Our Ref: LU/139/18/HH
Your Ref:

Town & Country Planning Act 1990 (as amended)
Town & country Planning (Development Management Procedure) (England) Order 2015
Application for Planning Permission for Works or Extension to a Dwelling

Development 2 storey side extension
Location 79 Clun Road Littlehampton

EXISTING LOCATION PLAN - 1 : 1250

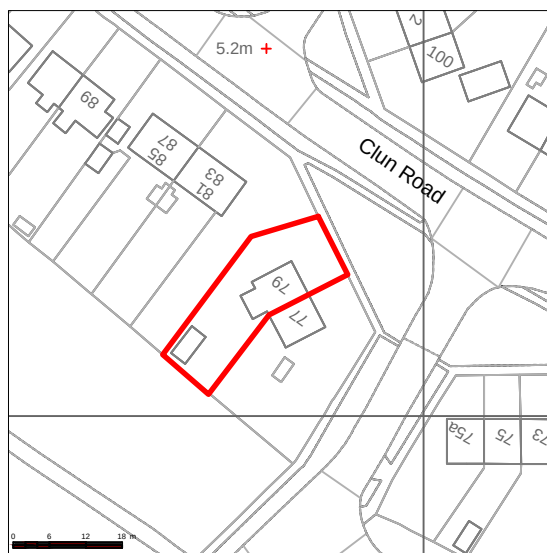
Location Plan - revised

Please submit 1 electronic or 3 paper copies of a location plan at a scale of 1:1250 or 1:2500 for rural areas. Further details of what must be included on the plan can be found in the National Validation Requirements.

You appear to have submitted a Location plan but have named it Existing Site plan - please re-name this document or provide a Location plan to scale.

PROPOSED SITE PLAN - 1 : 200

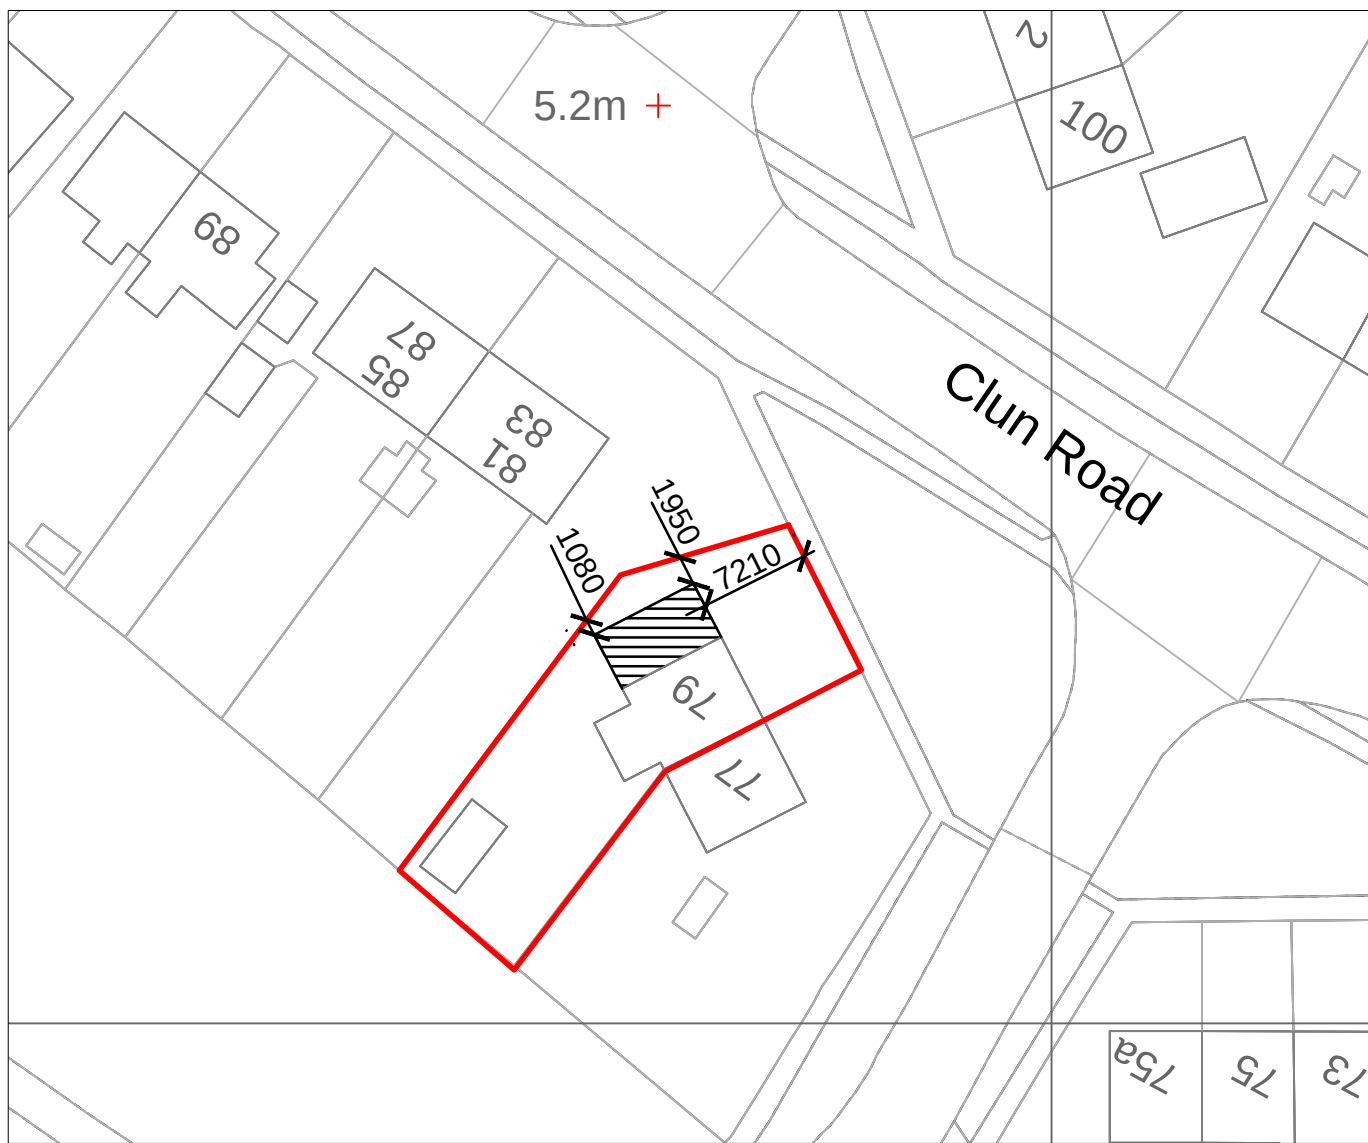
Block Plan - revised

Please submit 1 electronic or 3 paper copies of a revised block/site plan at a scale of 1:500 or 1:200 to include the site dimensions from the proposals to the site boundaries and to include 1 named road. Further details of what must be included on the plan can be found in the National Validation Requirements.
